Your Ref: OWPC18255
Our Ref: M/41/18/HH 22-03-2018
Please ask for:
Zac Denton

Extension to 1st floor incorporating rooms within the roof space for new 2nd floor & single storey rear extension with balcony above.

25 Sea Way Middleton-On-Sea

PROPOSED ELEVATIONS

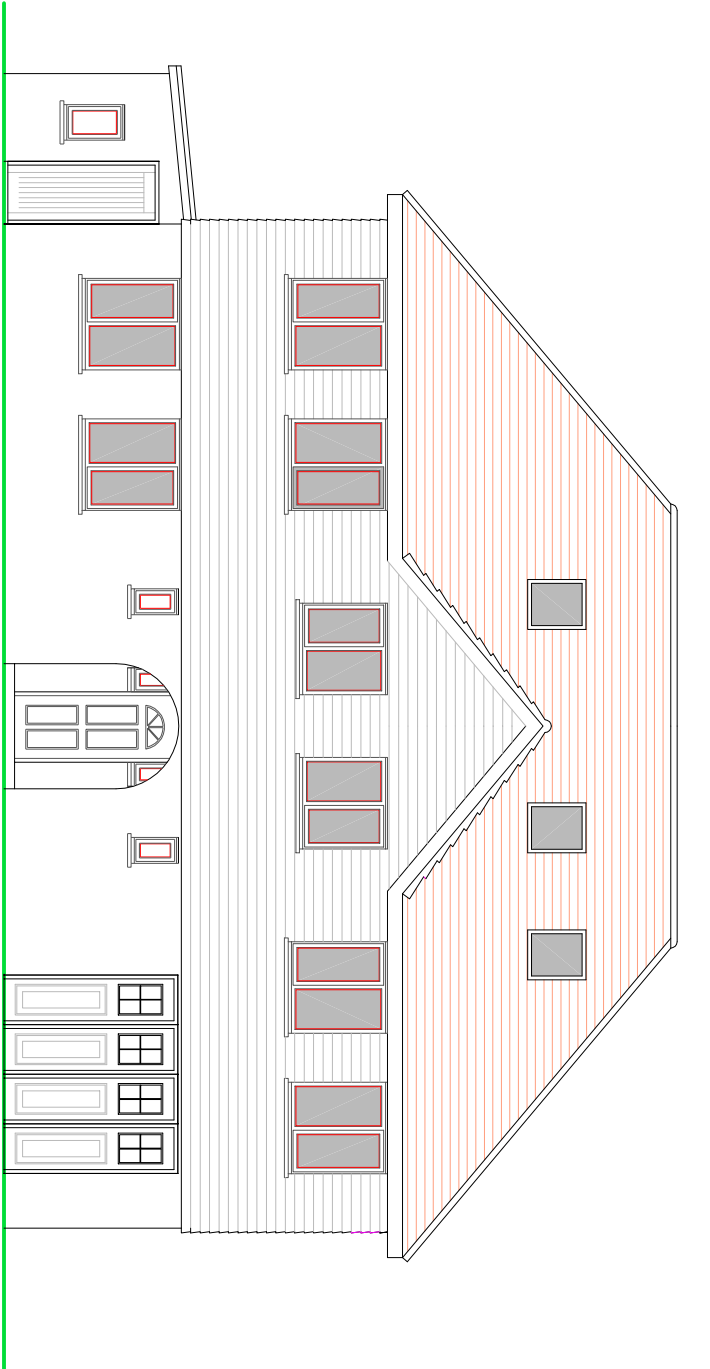
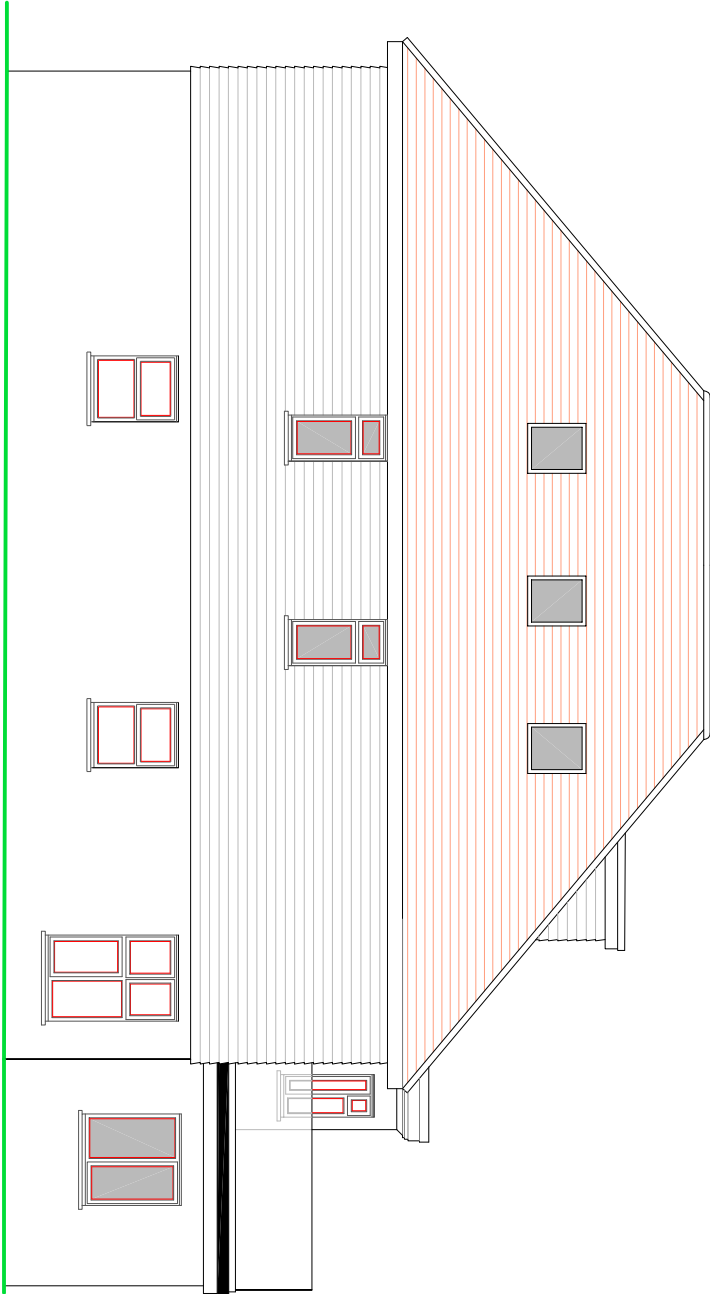
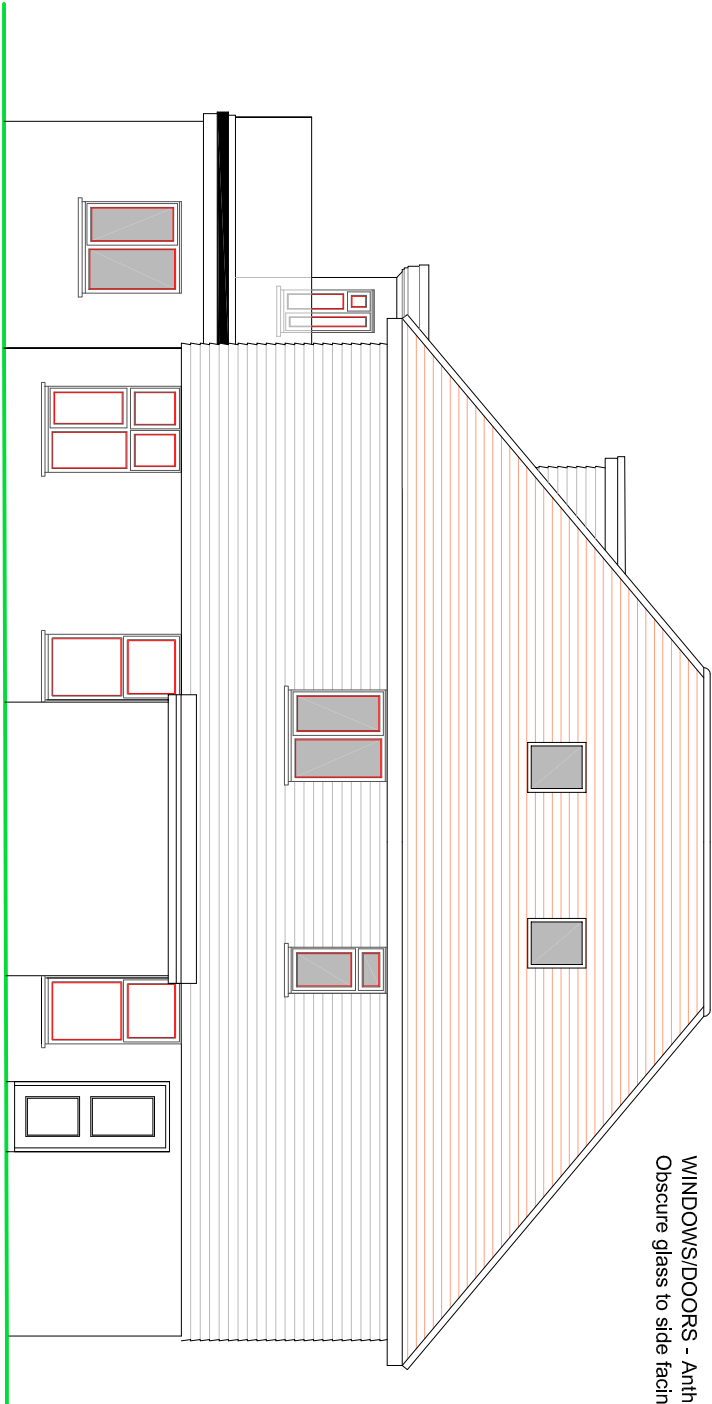
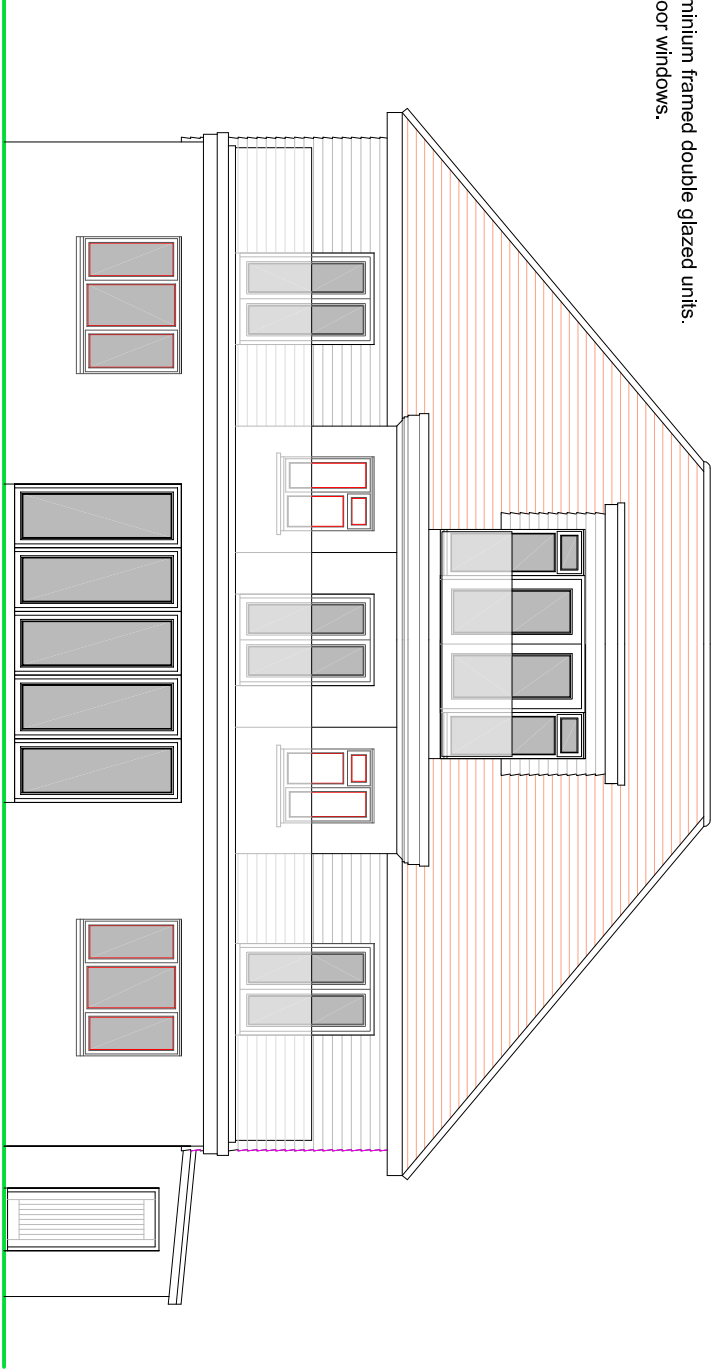
*In particular,
I draw your attention to the Village design statement,
the large increase in HEIGHT and size,
We do not want a precedent set in having three story building, (what next a block of flats.
I feel sorry for the neighbours who will be so overlooked*
